Appeal Decision

Appeal Ref: APP/R5510/D/20/3252850

127 Beverley Road, Ruislip HA4 9AP

- The appeal is made under section 78 of the Town and Country Planning Act 1990 against a refusal to grant planning permission.
- The appeal is made by Mrs Natalie Fahey against the decision of the Council of the London Borough of Hillingdon.
- The application Ref 48927/APP/2020/282, dated 28 January 2020, was refused by notice dated 24 March 2020.
- The development proposed is a two storey/ground floor side & rear extension.

PROPOSED SIDE ELEVATION  
SCALE 1:100

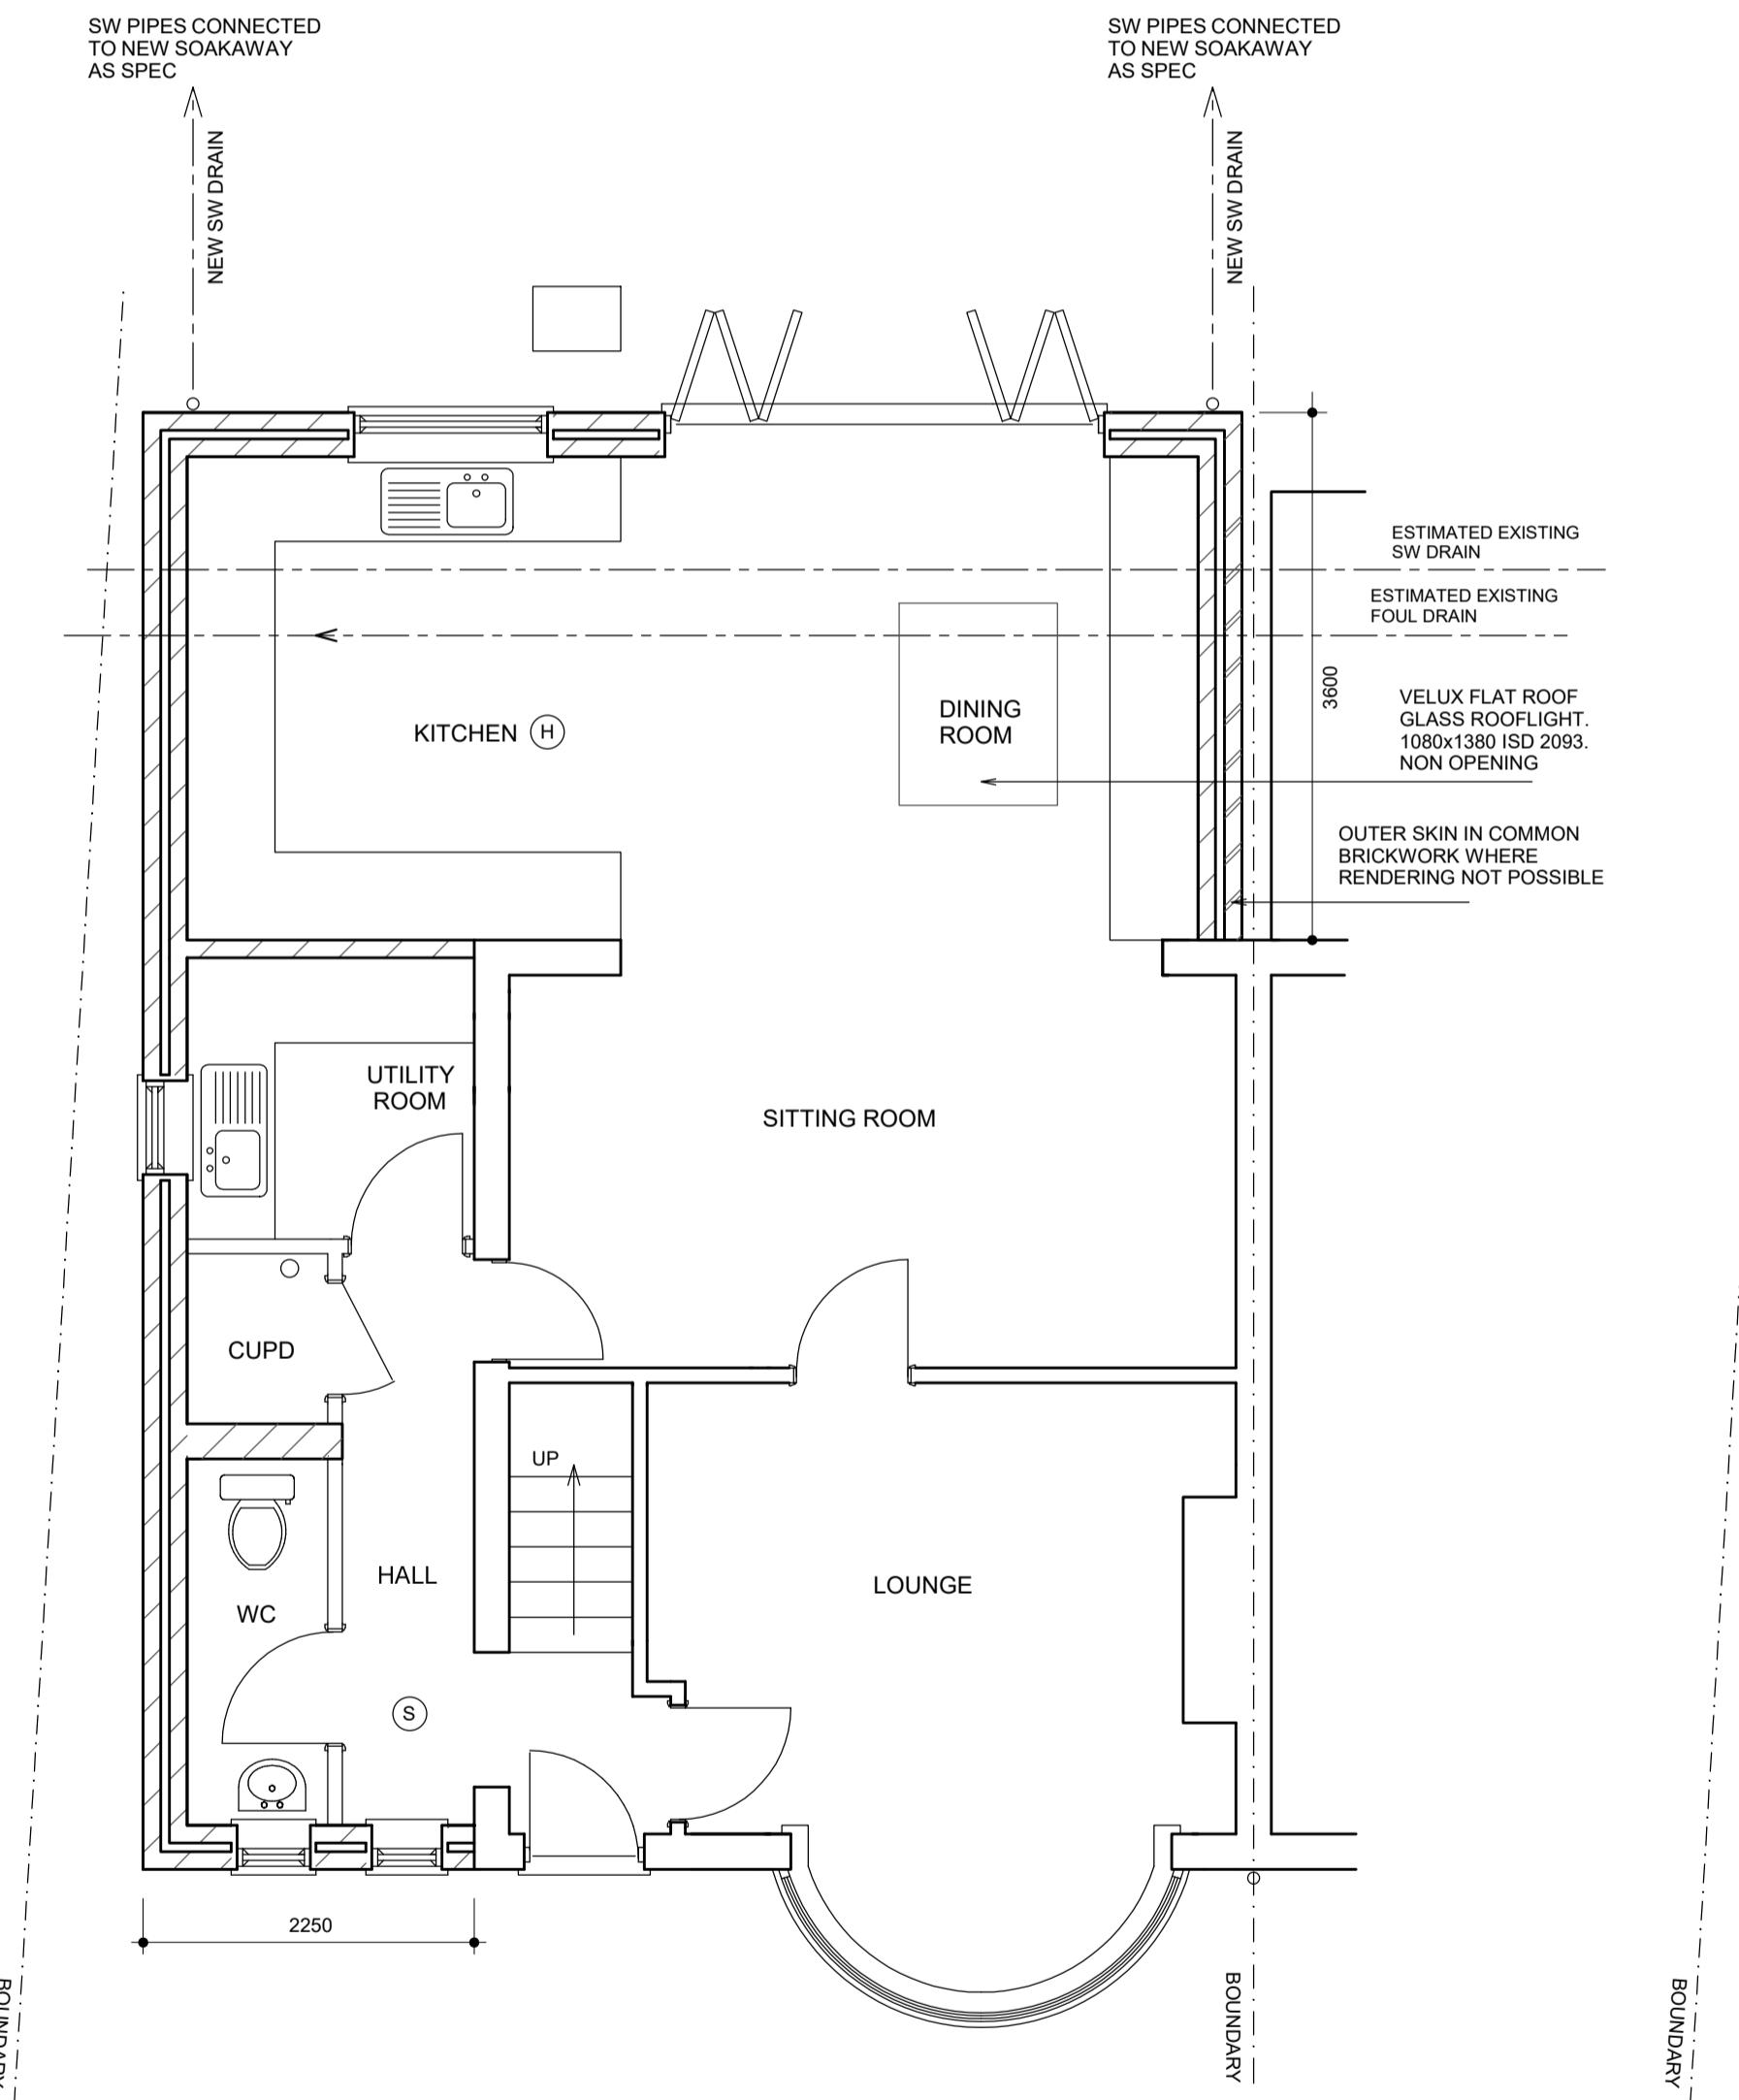
8. Whilst the ground floor of the extension would significantly reduce the gap between the dwelling and the northern boundary fence, the first-floor would be sufficiently set in from the boundary, set back from the main elevation, and set down from the main ridge as to ensure that the proposal does not appear as a cramped addition. Notwithstanding the prominent position of the dwelling within the street scene, given the siting and scale of the extension, the proposal would not result in an overdevelopment of the site.

9. Given that the appeal property has a larger gap to the side than the neighbouring properties opposite the road, the extension would be well incorporated without affecting the openness of the street scene to a detrimental degree. Moreover, given the size and scale of extensions elsewhere in the vicinity of the site, including on the opposite side of the road, the proposal would not appear unduly dominant in the street scene.

PROPOSED GROUND FLOOR PLAN

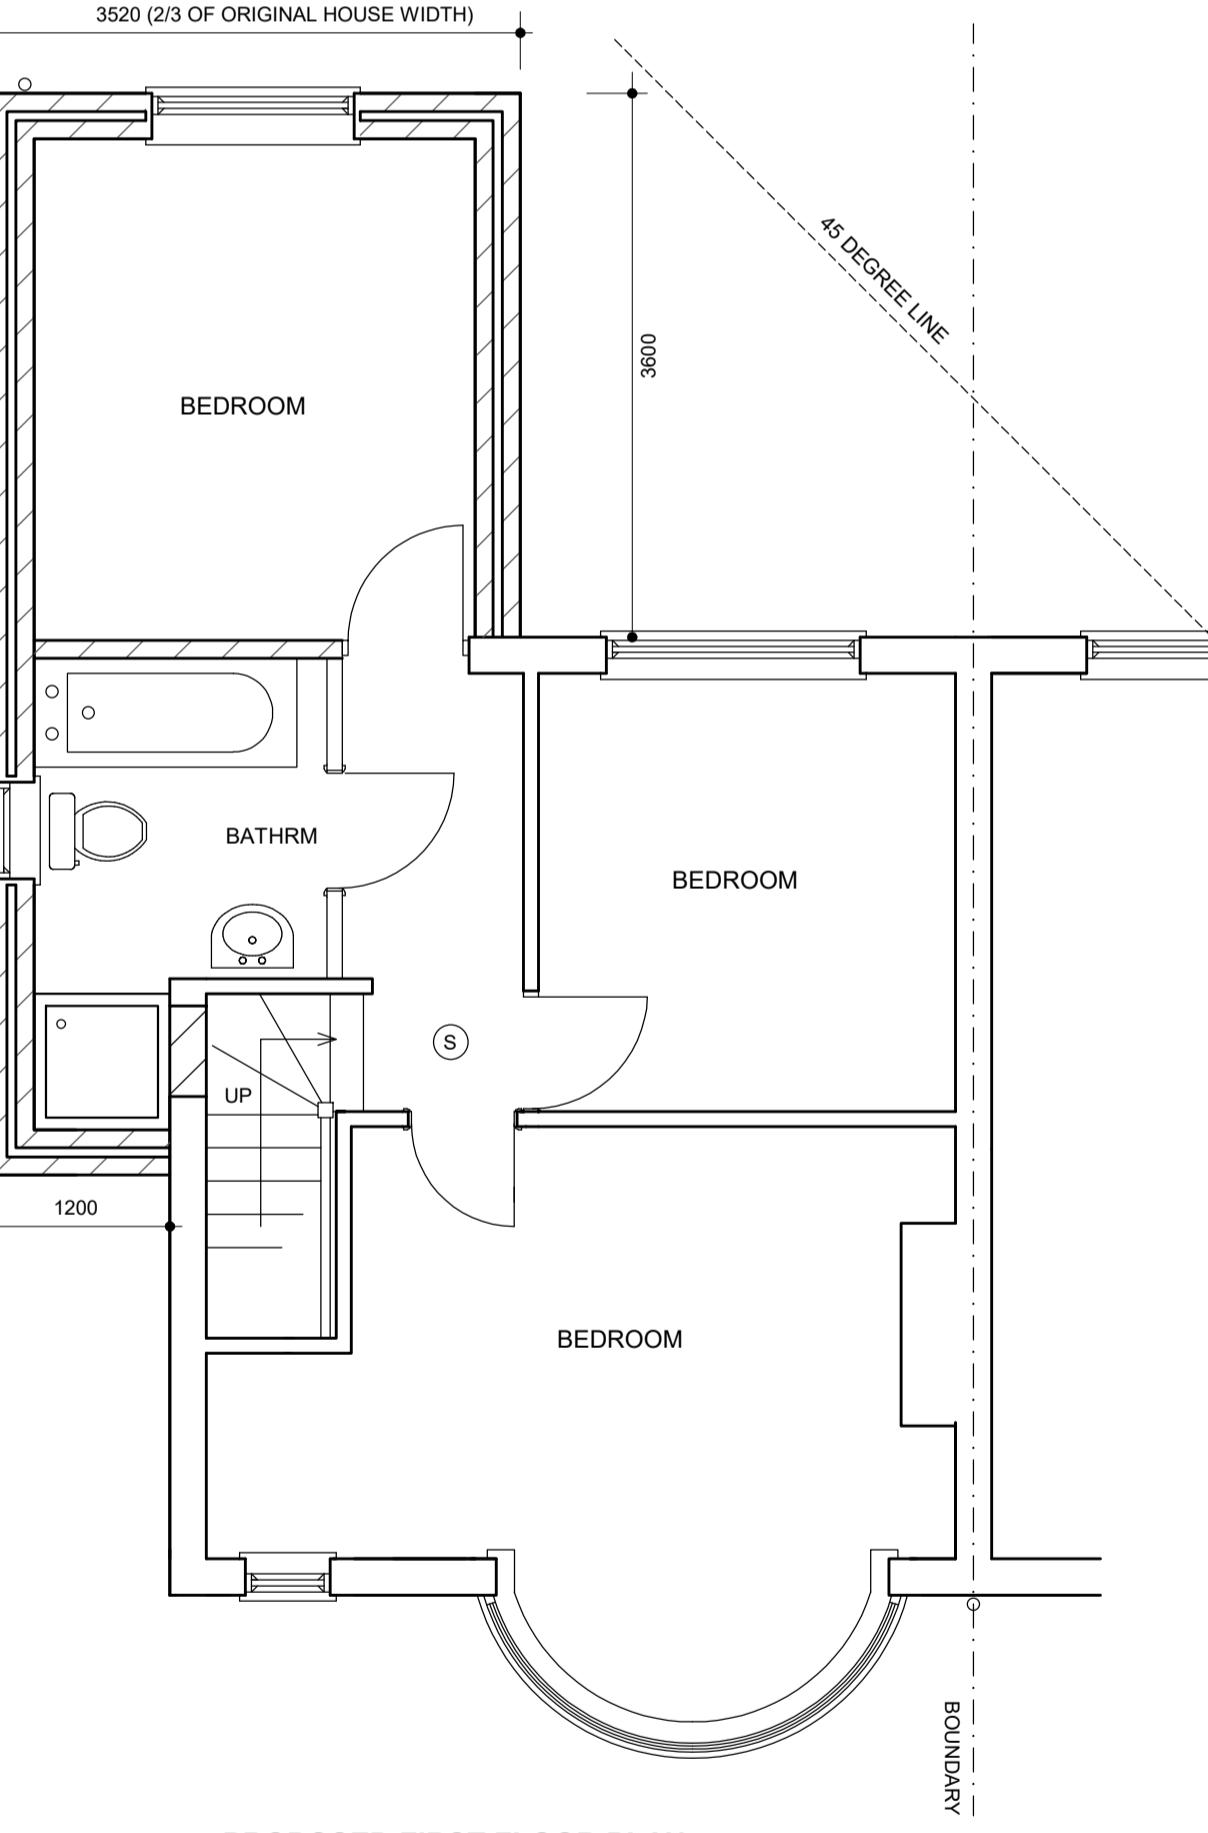
7. The ground floor of the side/rear extension would be flush with the main elevation and would fully wrap around the side and rear elevations of the host dwelling. The northern side fence is at an angle with the house, thus whilst the extension would have a constant sideways projection, the gap between the ground floor extension and the boundary would decrease considerably towards the rear. The first-floor of the side/rear extension would be well set back from the main elevation and set in from both sides.
